The Sizewell C Project EN010012

D3. Comments on SZC Co's response to the ExA's 1st Written Question (ExQ1),

REP2-110: 9.11, Vol 3 Appendices, Part 3:

'Relevant examples of recreation of fen meadow habitats', BIO 1.86.

Figure 3.3
Fen meadow compensation potential
for Aldecar Lane, Benhall

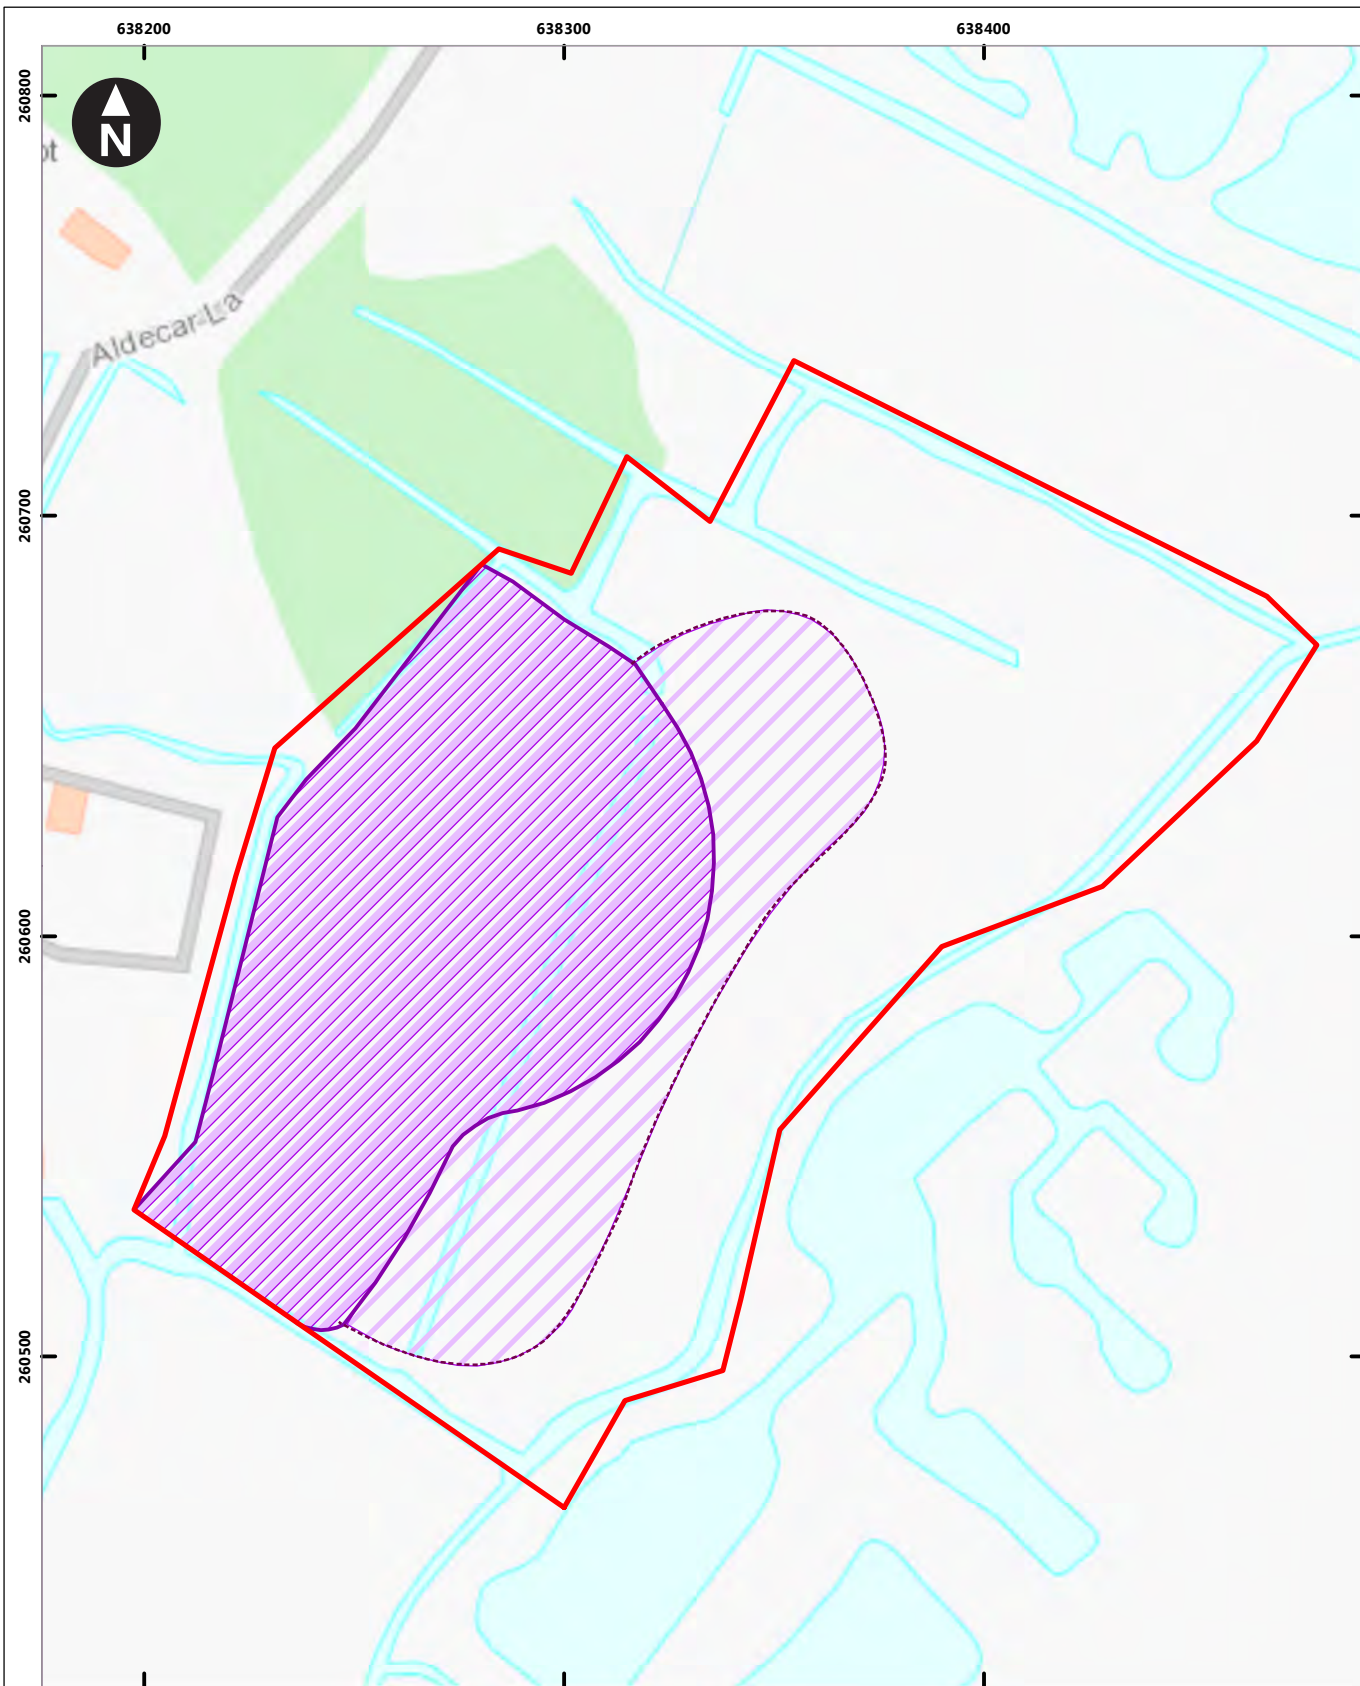
This leaves the question of water quality, that needs to be low in nutrients for fen meadow plant and invertebrate communities to flourish. As local people, we know that the proposed site at Benhall, for example, is high in phosphates due to regular flooding from the sewage works. It is our view that this would not be suitable for fen meadow creation.

Figure 3.13a
Fen meadow compensation potential for Pakenham Fen north site

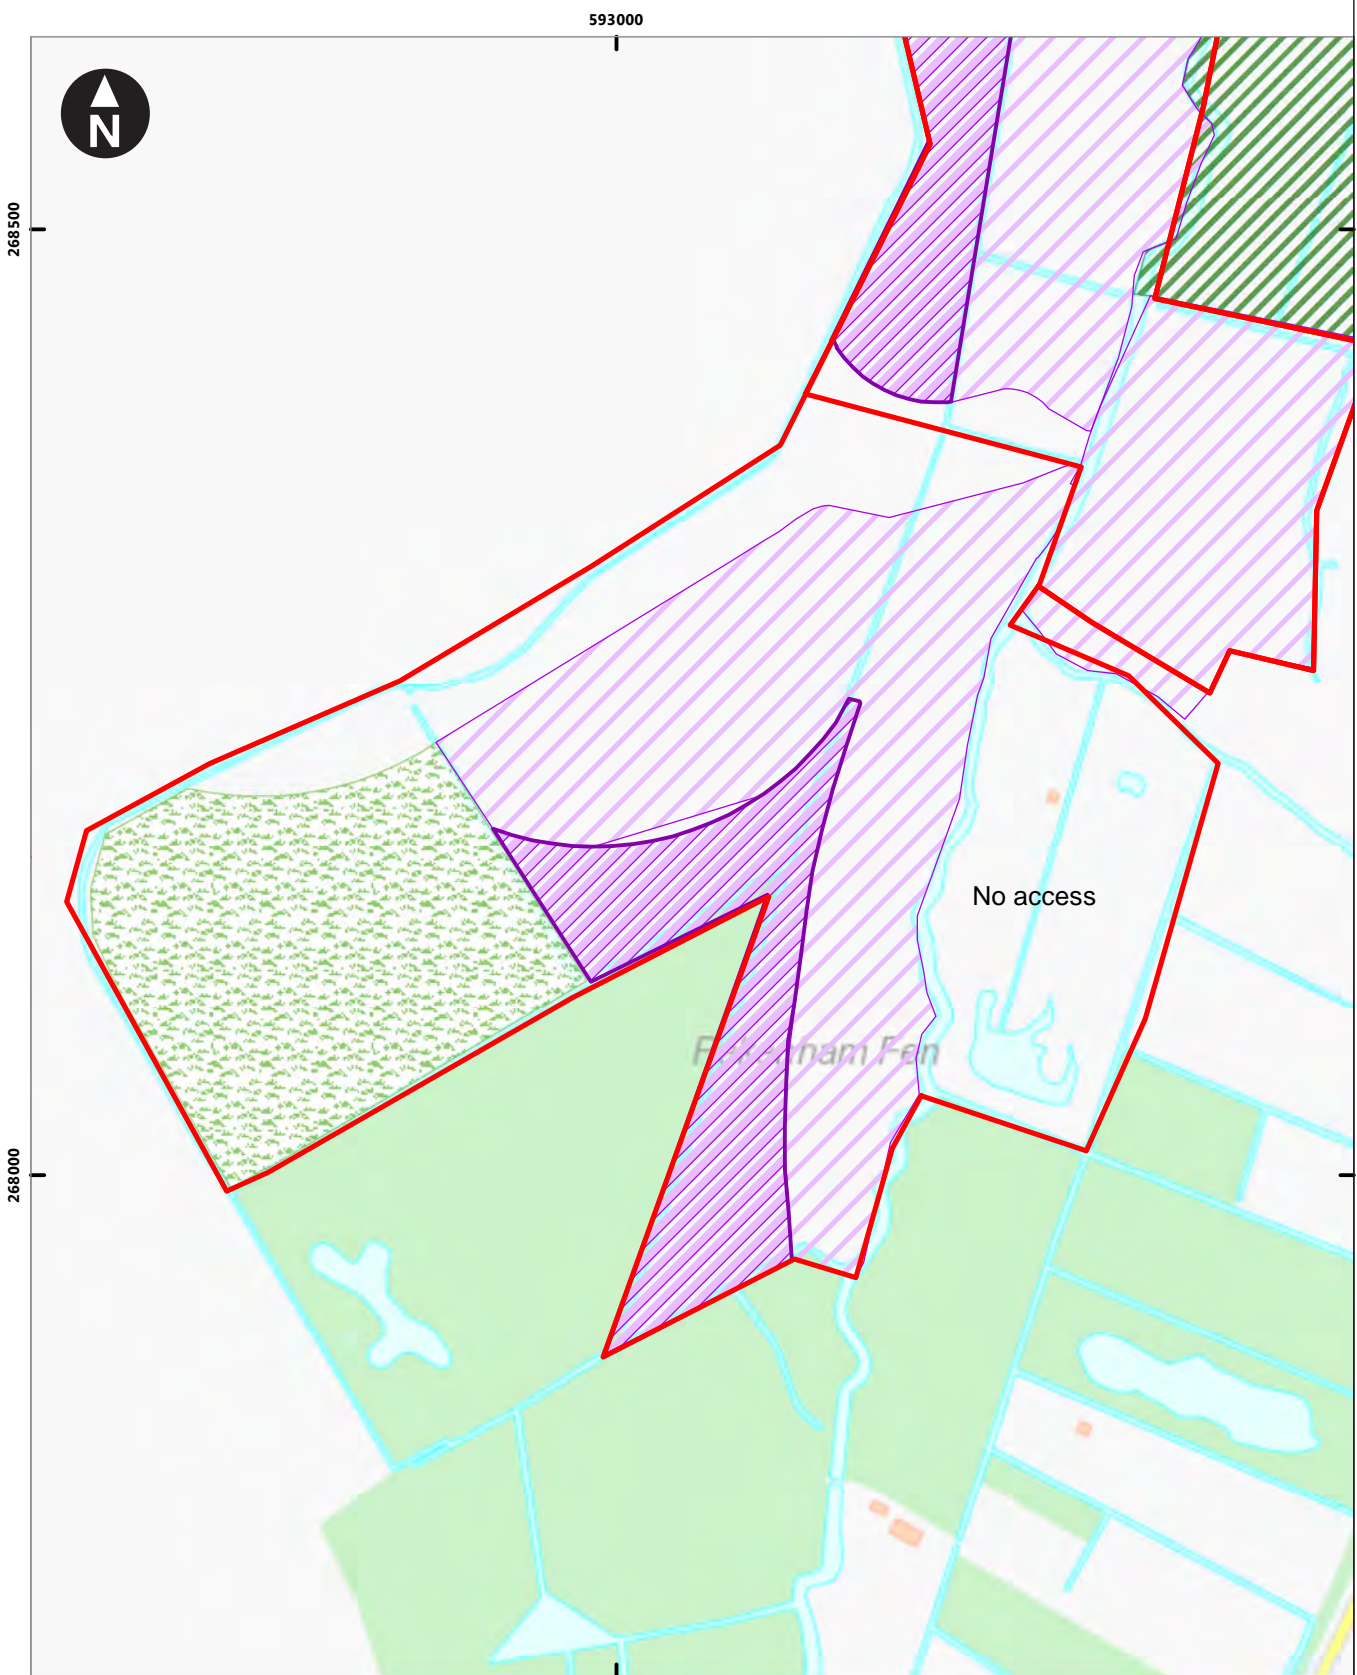
1.2.7 As part of the 'recipe', topsoil removal is recommended. We would like to point out that this may not be possible at Pakenham as the ground is so waterlogged, it is unlikely that heavy machinery could be driven on to it.
